From:
Sent: 29 November 2018 11:59
To: DCAdmin
Cc:
Subject: 2018/92647 Former Kirklees College New North Road, Huddersfield
Attachments: hdm comments.docx

Highway Development Management's (HDM) comments for the above application as follows:

Planning application for the mixed use development of former Kirklees college site to form retail/office units and 239 residential units associated access and car parking provision.

Scale @ A1 : 1/200

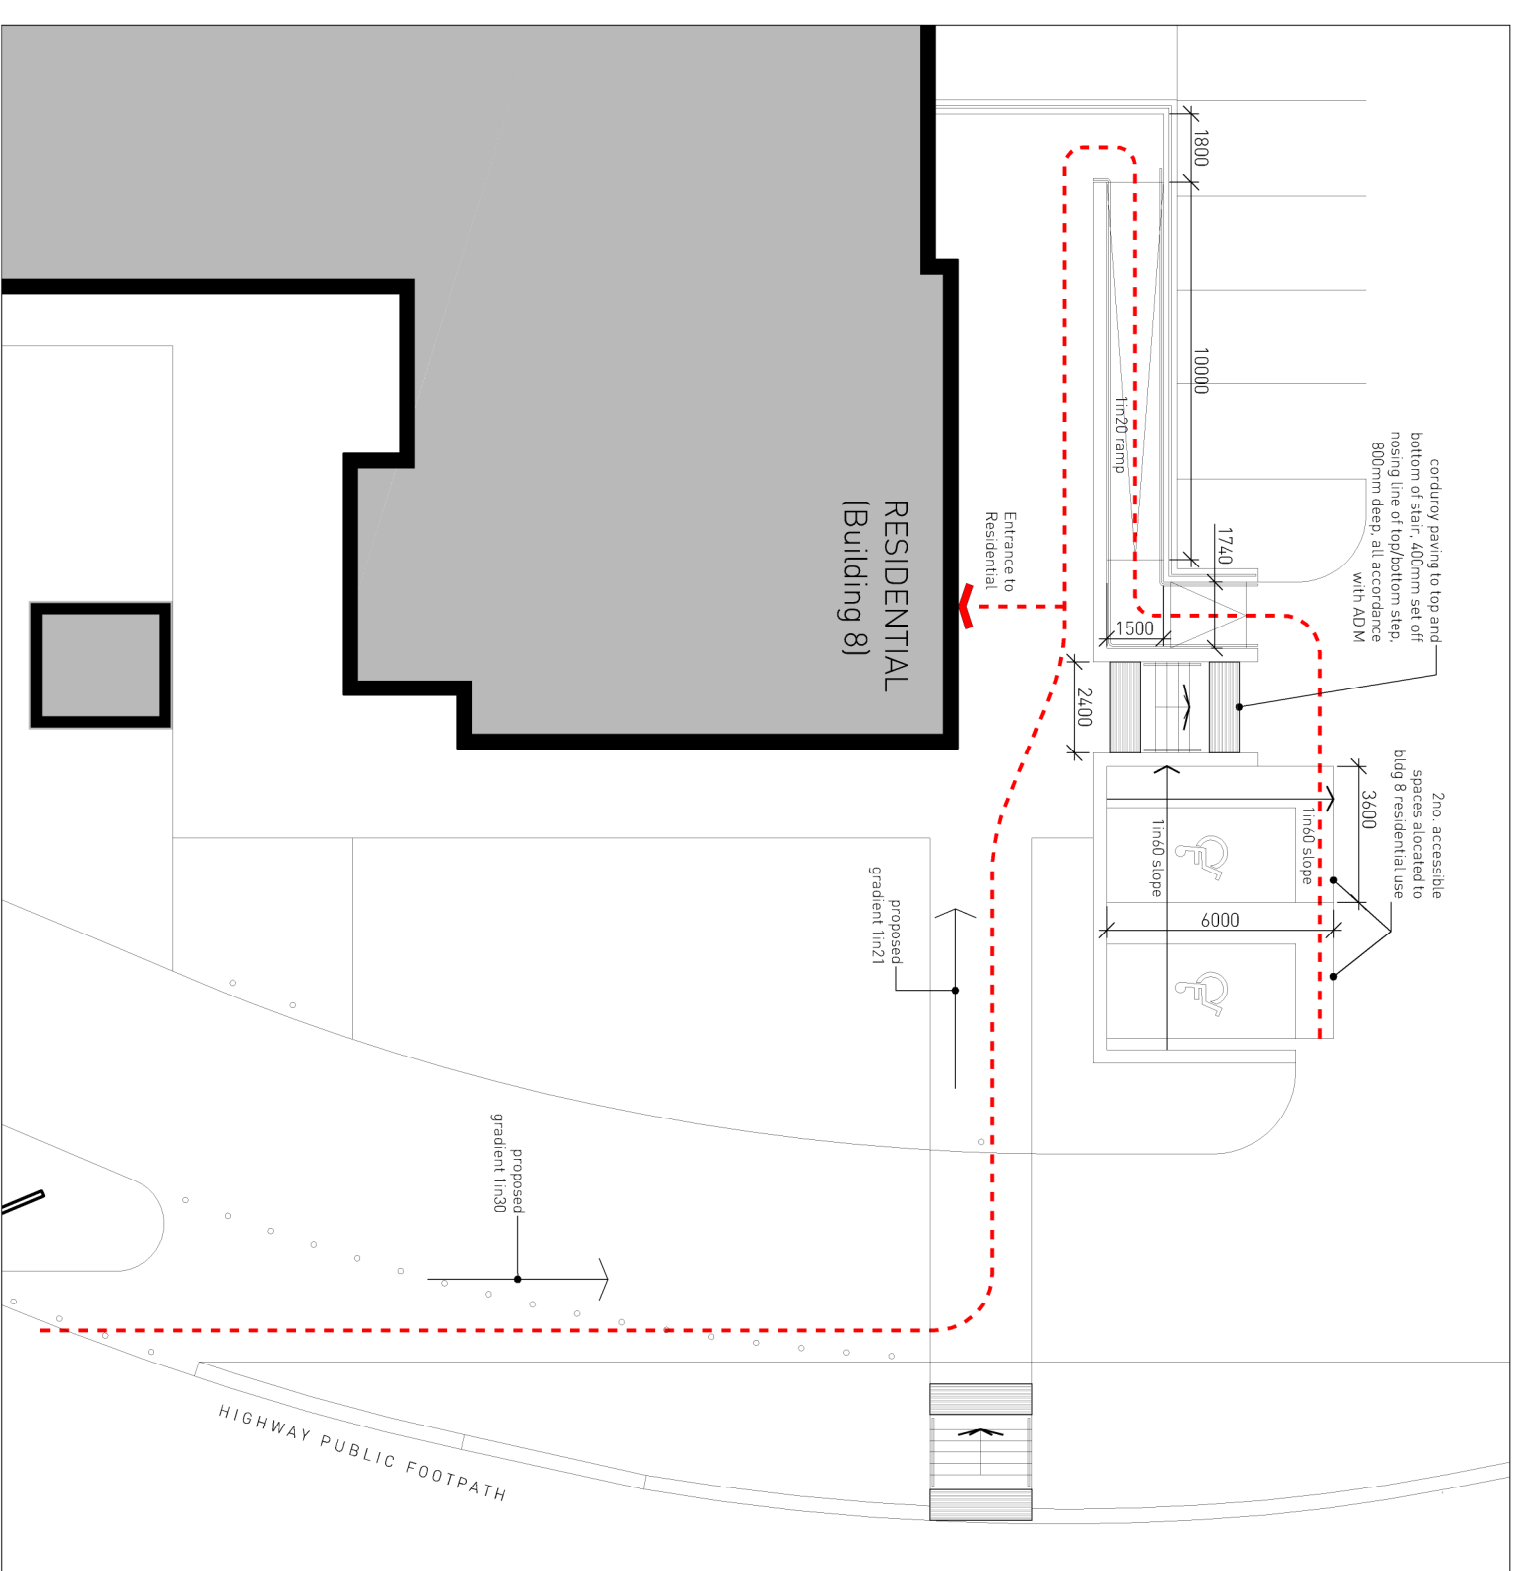
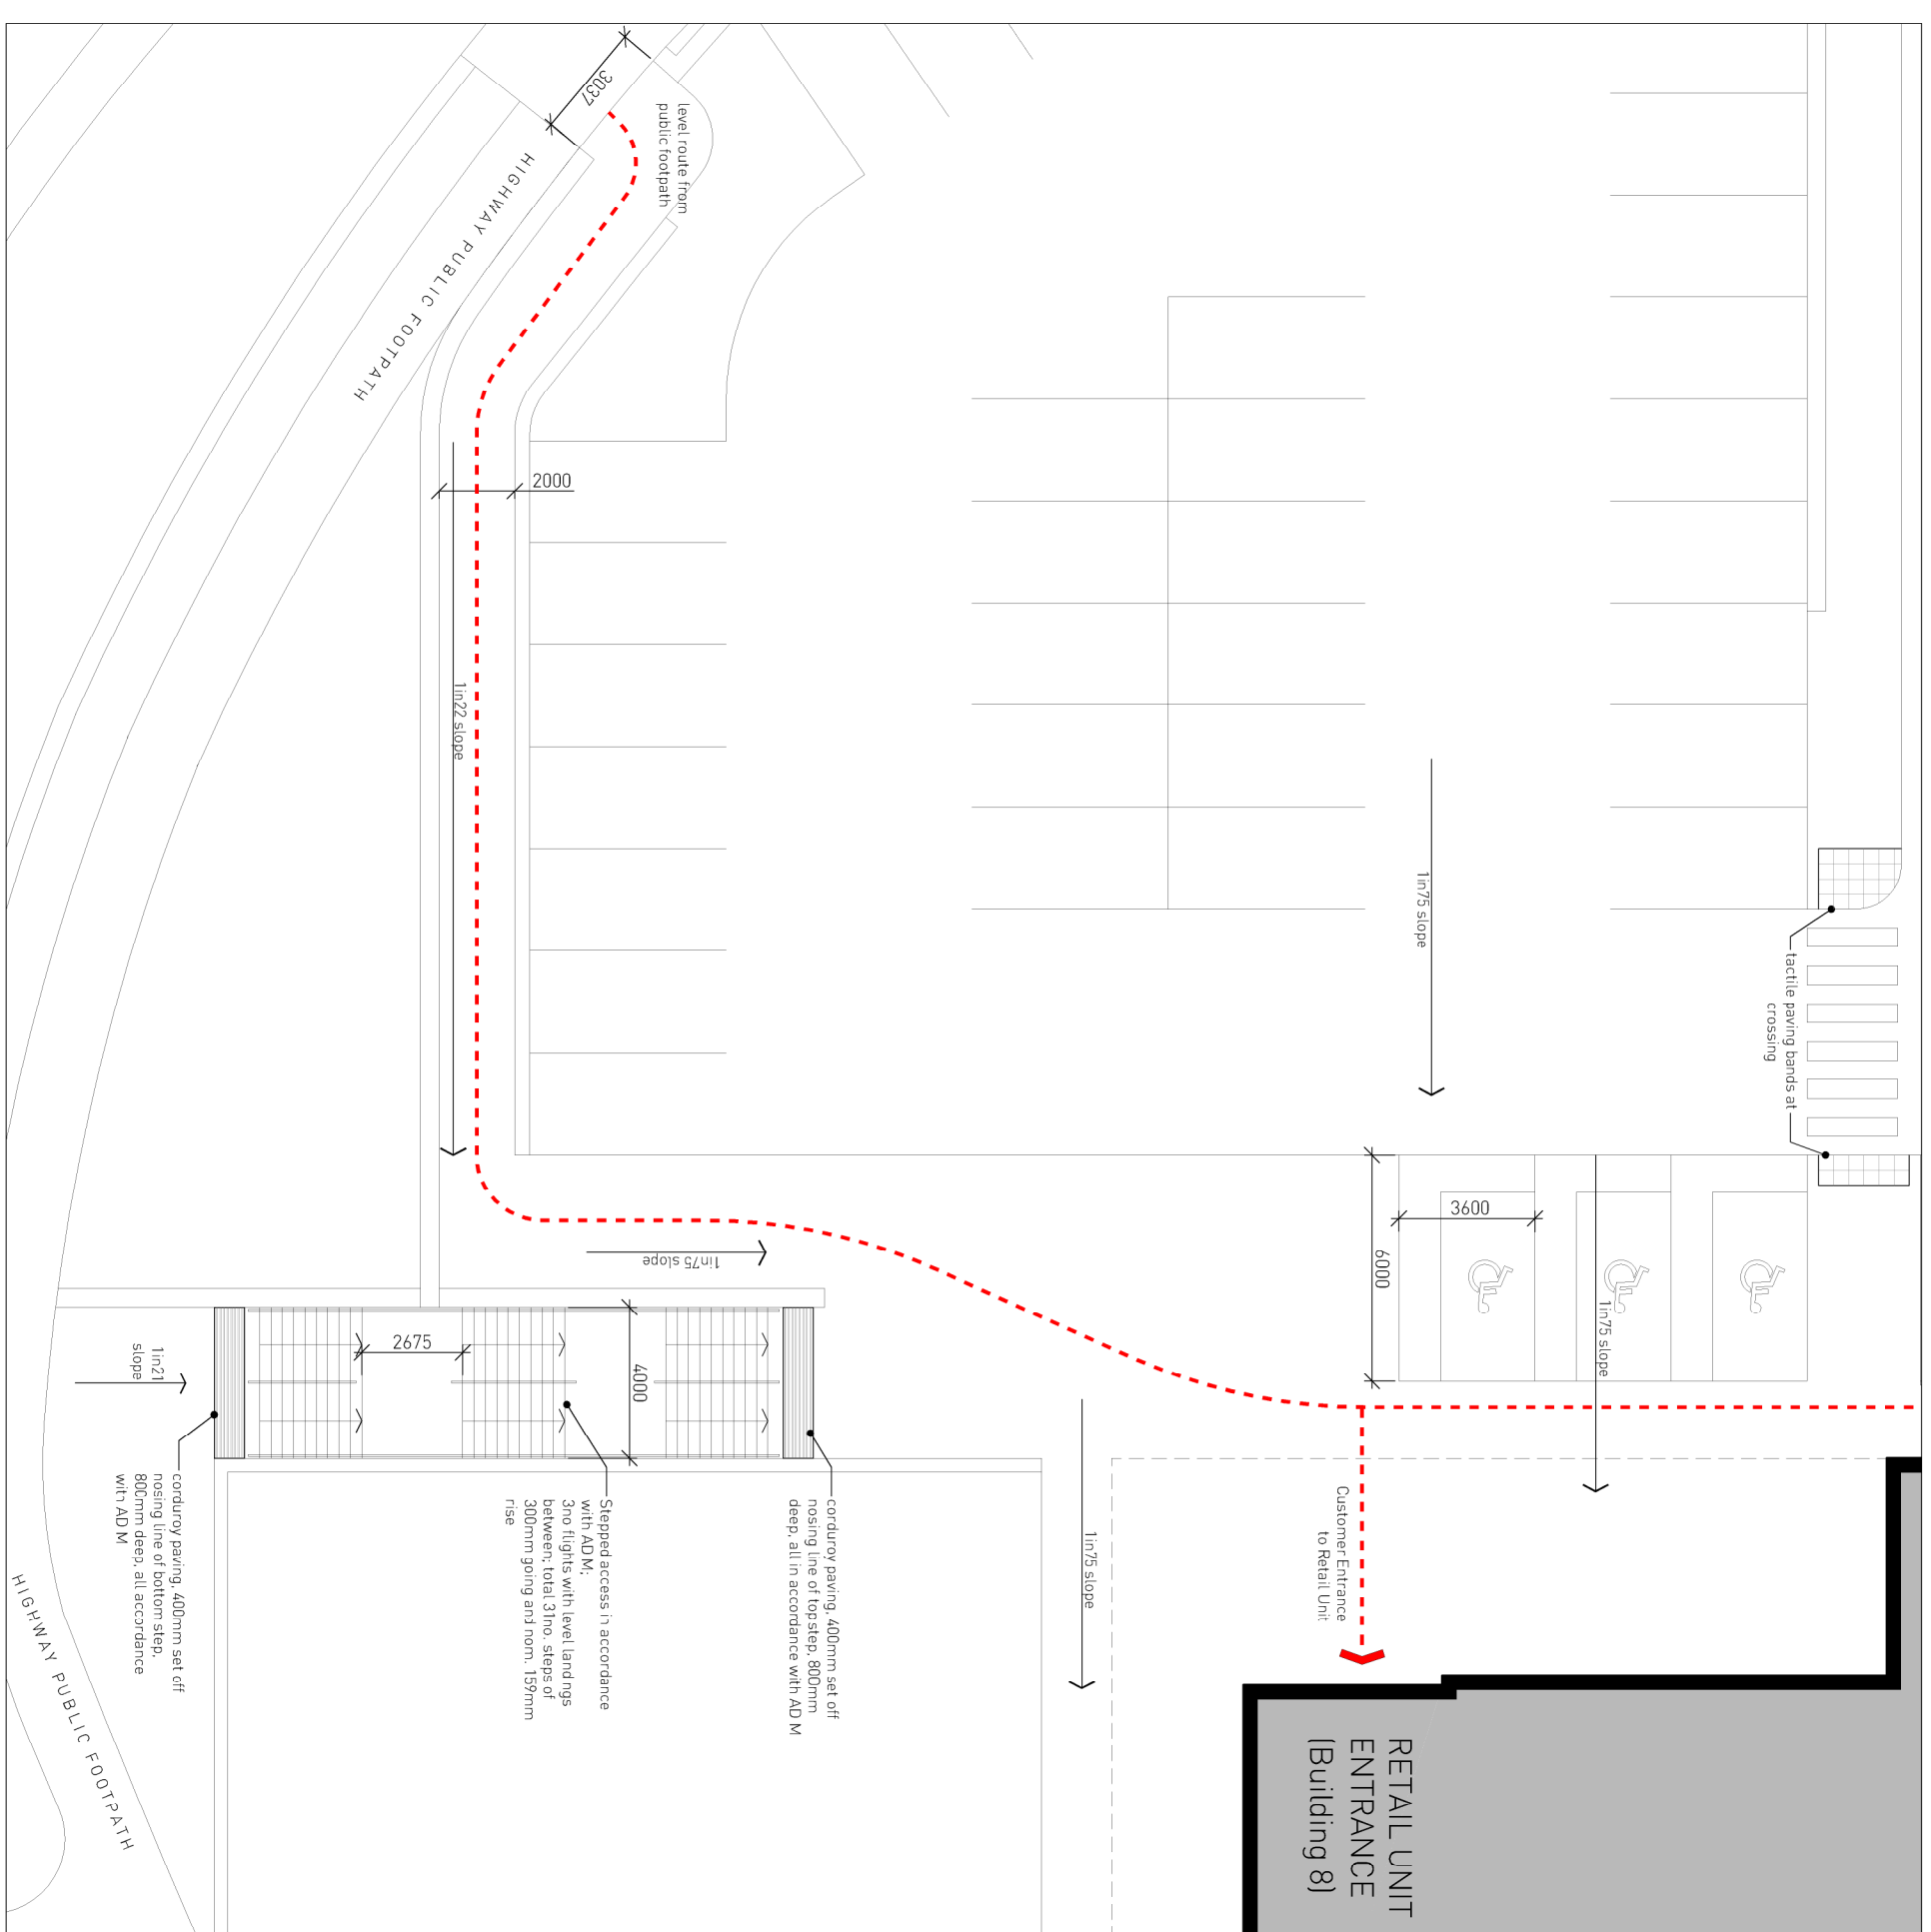
- Improvements to the existing subway are required to improve pedestrian safety.
- Vehicle Priority in and out of all site entrances needs clarifying, some access widths appear too narrow to accommodate two way traffic.
- Dependent on the access arrangements, appropriate visibility splays should be demonstrated.
- The width of the existing footway along the site boundaries should be improved to aid pedestrian safety/landscaping.
- A stage 1 safety audit and designer's response to cover all aspects of works should be submitted.
- Pedestrian routes within the site should be of 2.0m min width.
- Refuse collection arrangements need clarification.
